File No: NTH09/01607
Your Ref: PA 09_0080 MOD 4

**Pacific and Bruxner Highways [HW10 & 16]: Major Project. Champions Quarry.
Modification 4 (PA 09_0080 Mod 4). 1668 Wyrallah Road Tuckurimba.**

Date: 11 July 2018

Figure 7 – Warrant for turn treatments

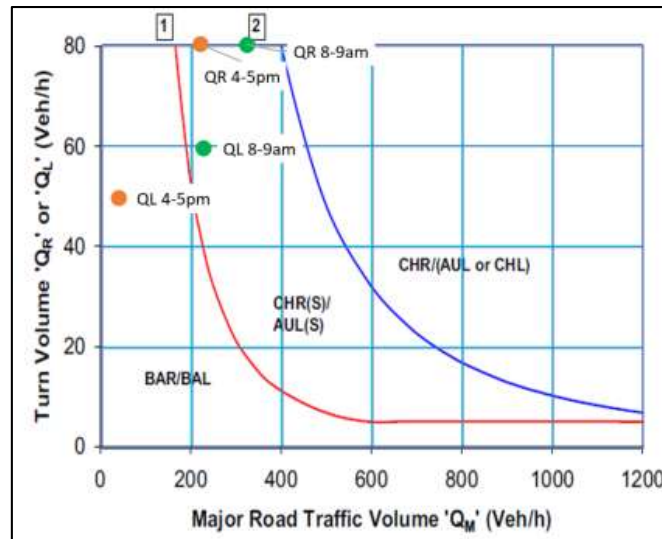
- Project Approval 09_0080 dated 30 August 2012 Condition 23(b) required construction of a left-turn lane for northbound traffic at the junction of Wyrallah Road and Wyrallah Ferry Road. It is unclear if this has been undertaken to date.
- No turning paths for the largest vehicle have been provided at key junctions such as Wyrallah Road and Broadwater Road along the haulage route to assess if turns can be undertaken safely.
